**Subject:** 2020/90480 Parkwood Methodist Church, Parkwood Road, Longwood, Huddersfield, HD3 4TT  
**Date:** 08 November 2020 14:54:32

Thankyou for your consultation to the Ancient Monuments Society ( which is concerned with listed buildings of all ages and all types ).

Proposed Plans & Elevations

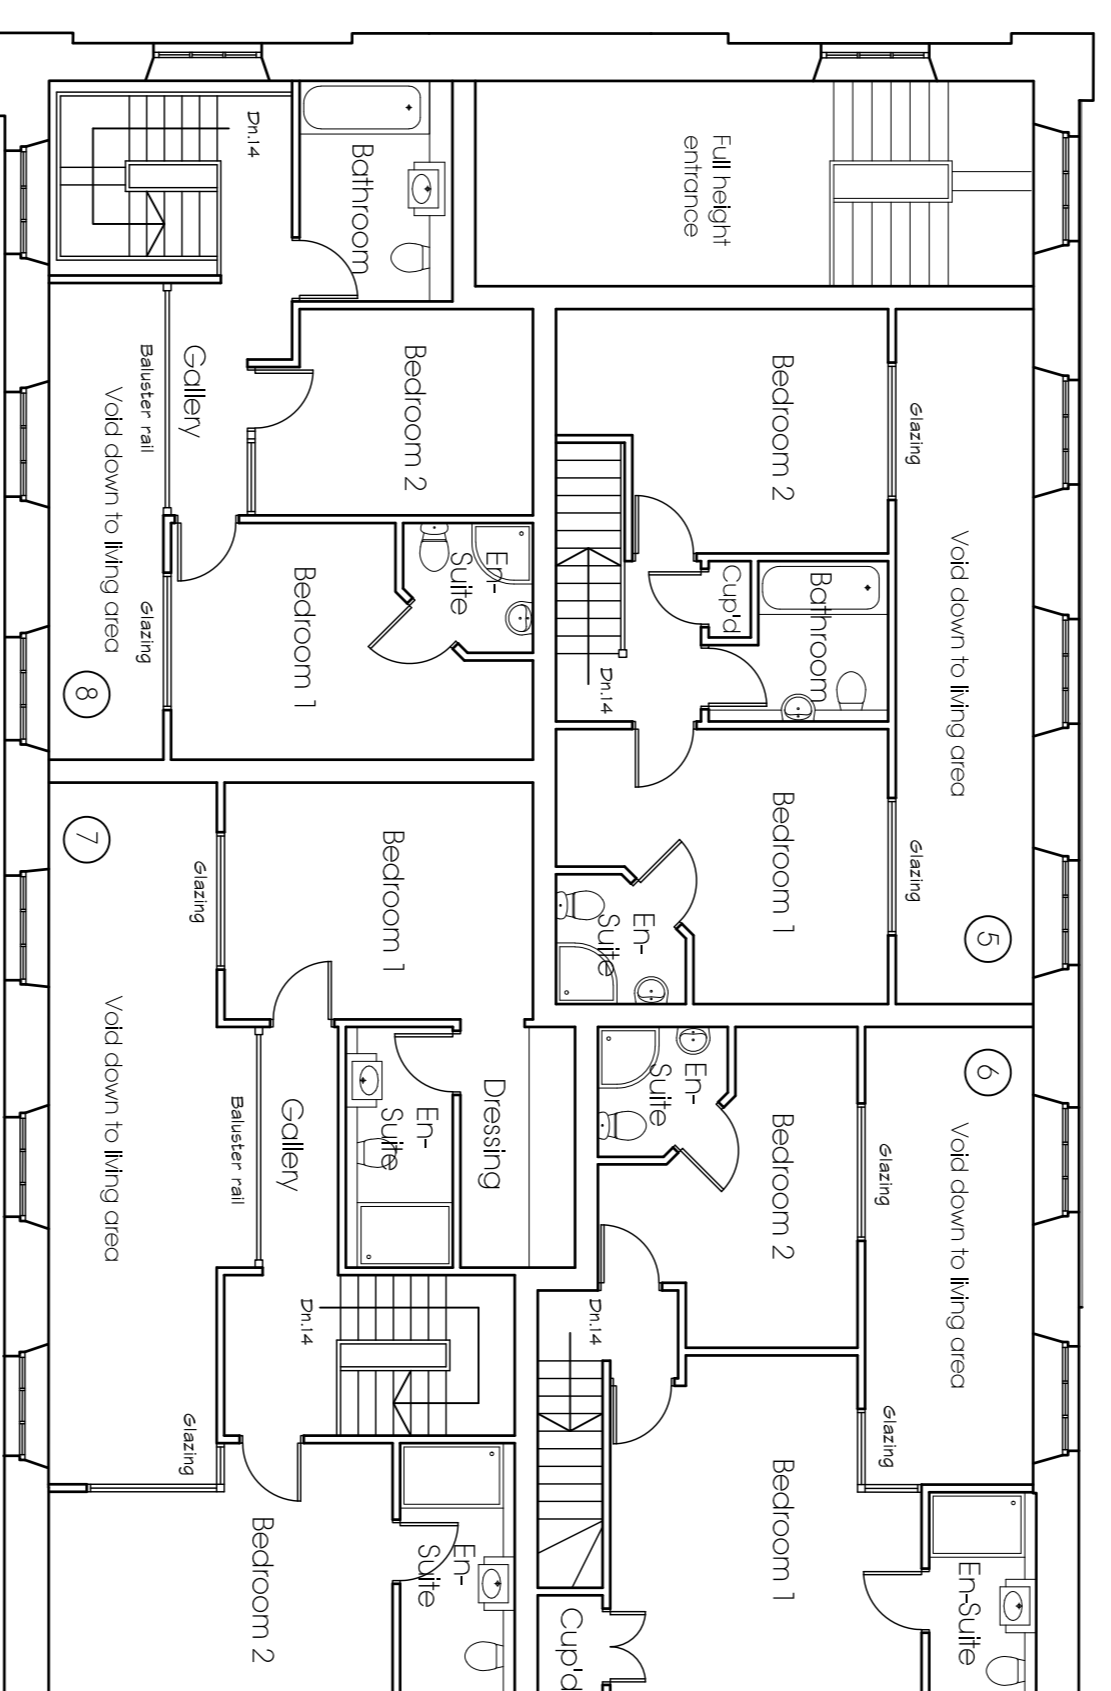
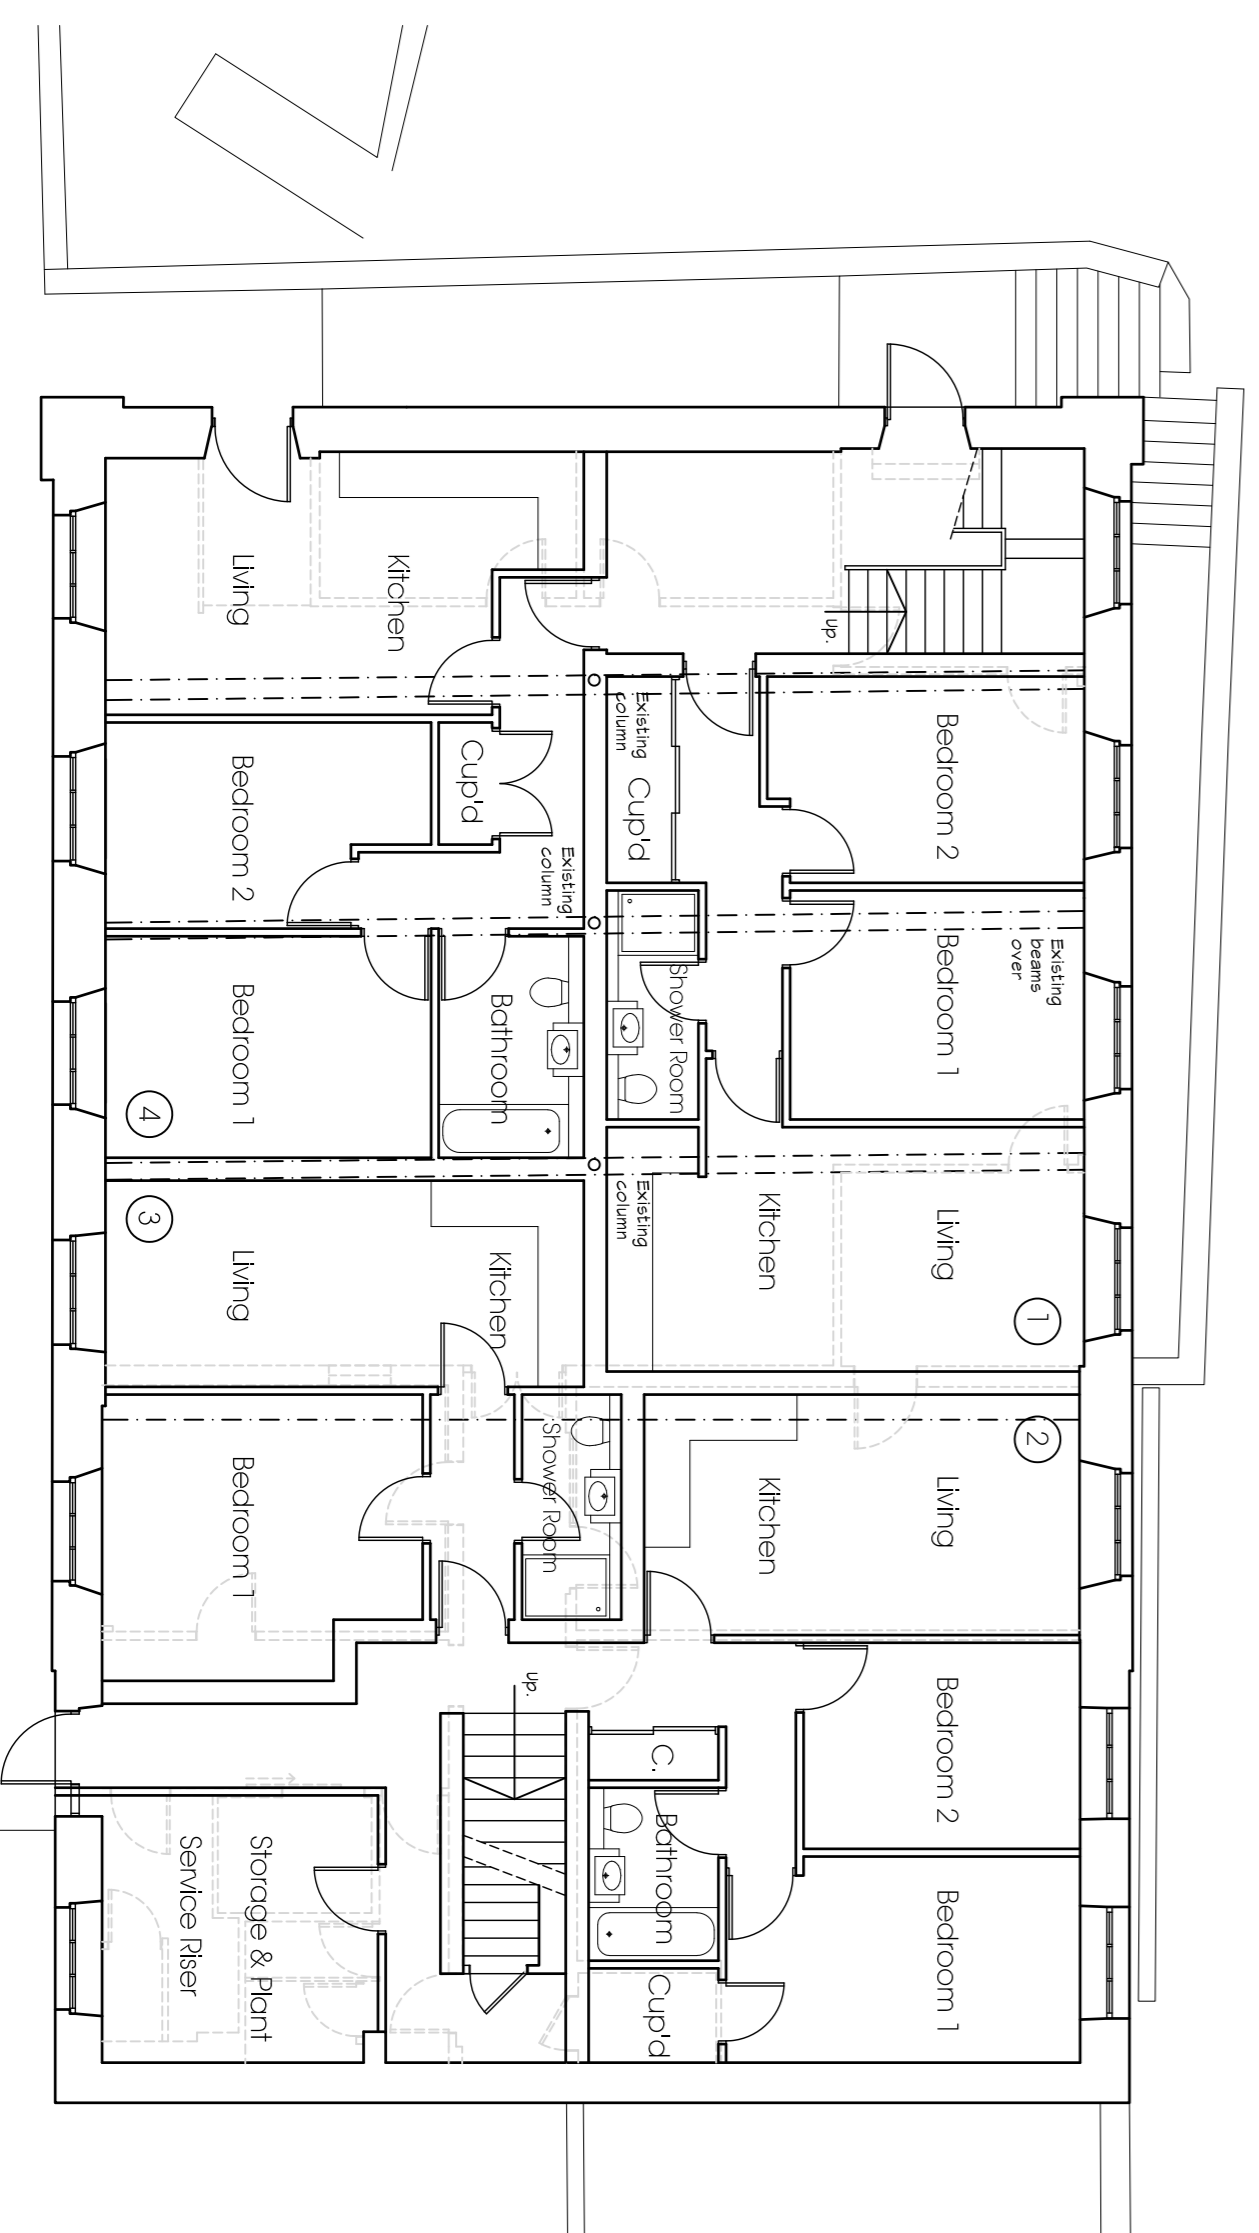
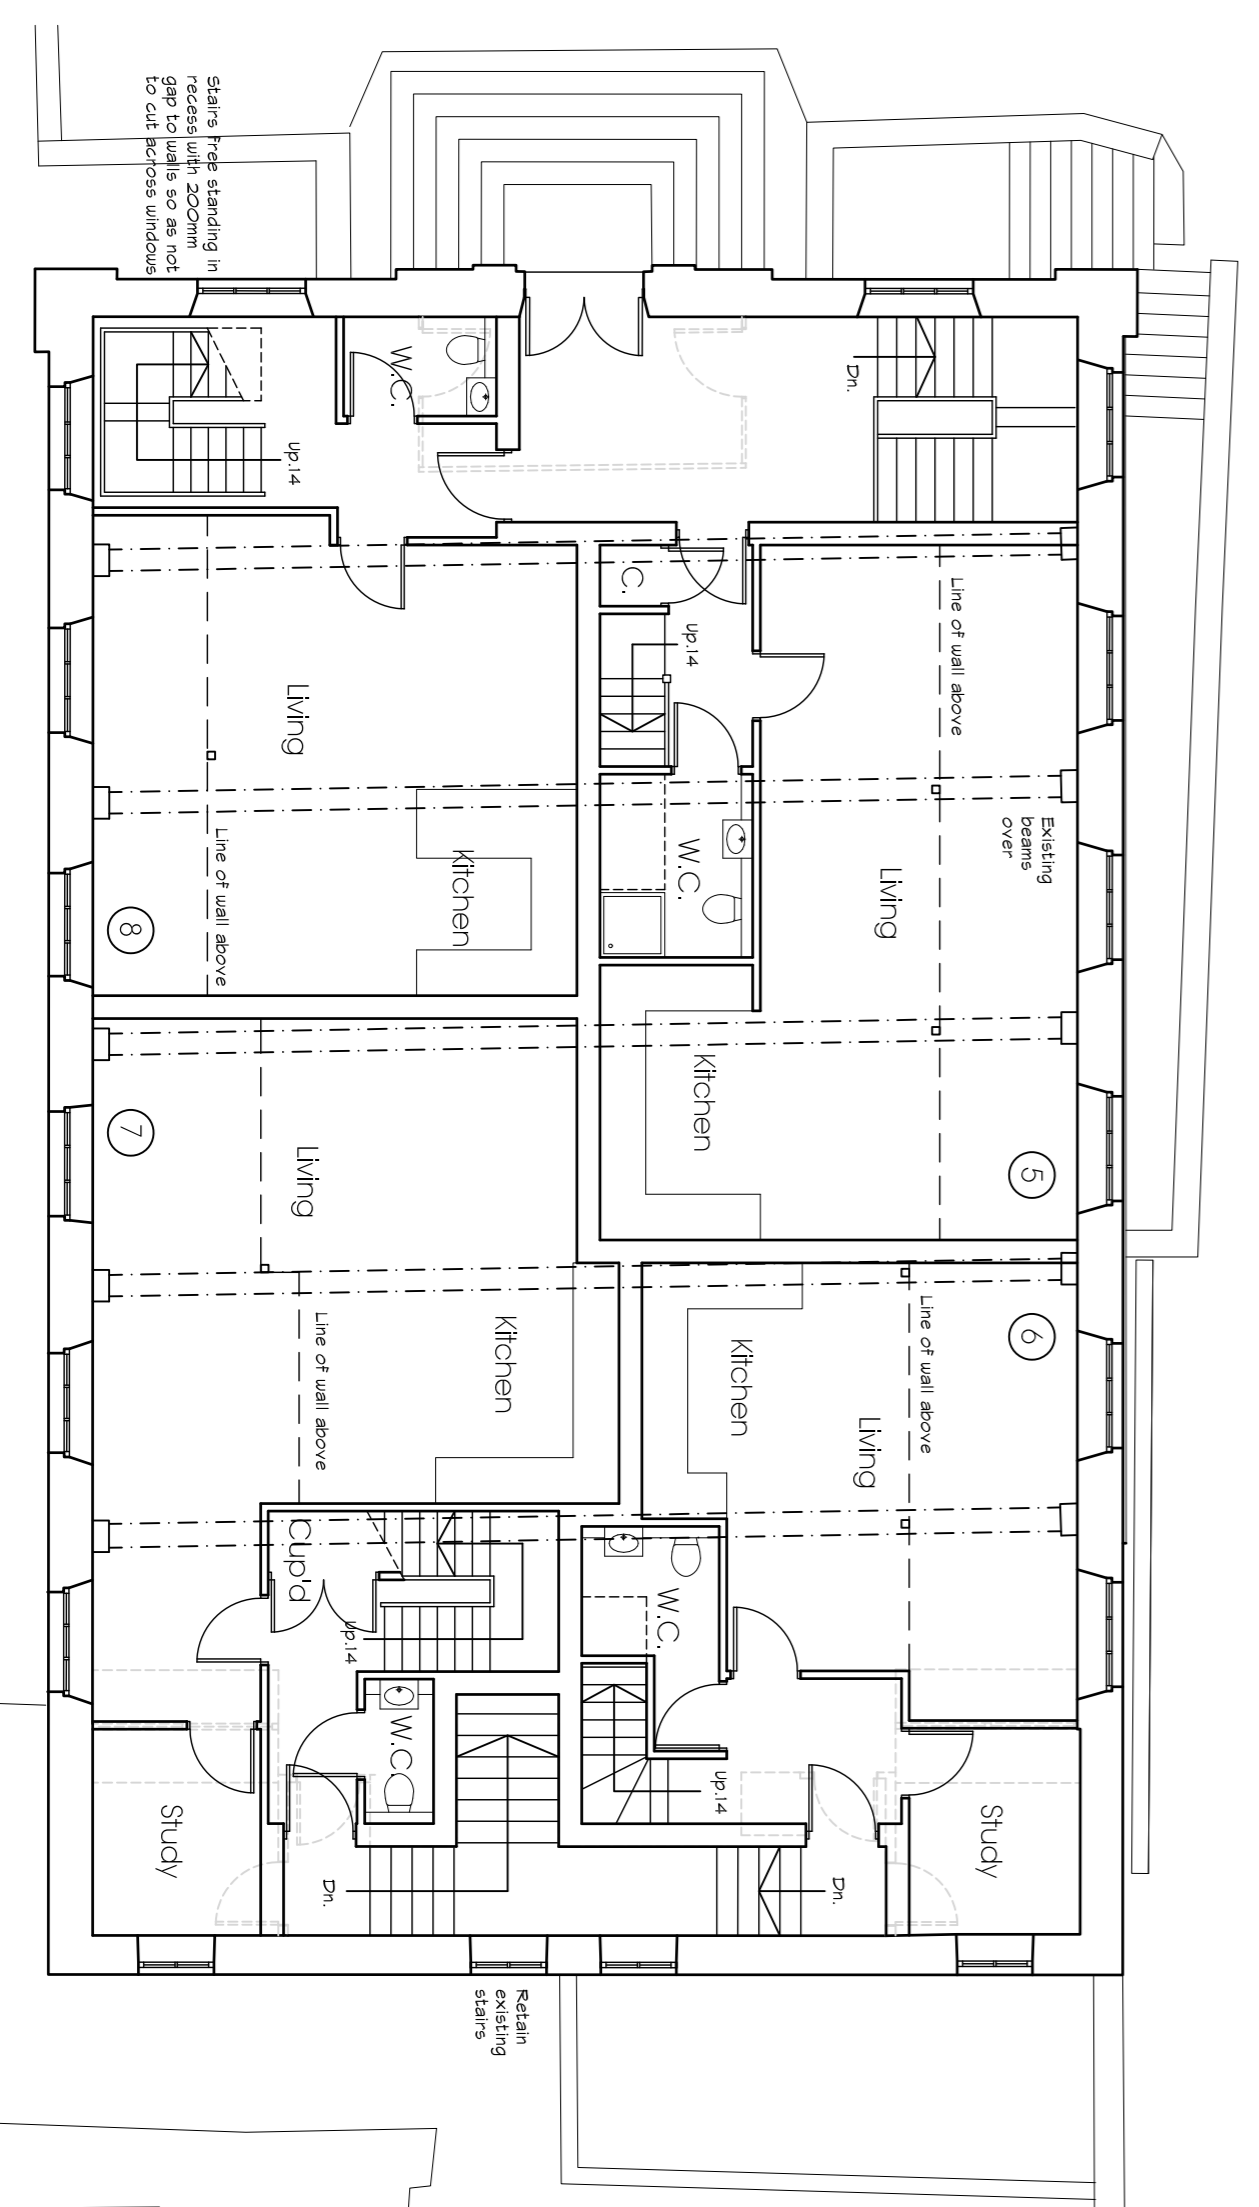
We join with them in expressing dismay that the scheme as proposed envisages the loss of all internal elements, apart from, we assume, the downstands, the console brackets supporting them and the “roses” on the present ceiling. Everything else that lends the interior historic character, dignity and presence – the pews, the pulpit, the organ, the unusual tiered seating, the monuments, the stained glass shown in the photo at 2.18 in the Heritage Statement – would all go. 3.09 of the same statement refers to a suggestion that “if any of the features can be utilised in the conversion proposals this re-use will be considered”. But the revised plans ( dated 6<sup>th</sup> October 2020 ) confirm that nothing at all is to be kept.

This gutting is then compounded by the insertion of a new suspended floor which, along with the asymmetrical, heavily cellular, subdivision of the interior, will destroy any sense of the present openness. The floor will also cut across the substantial windows and be clearly visible from the outside.
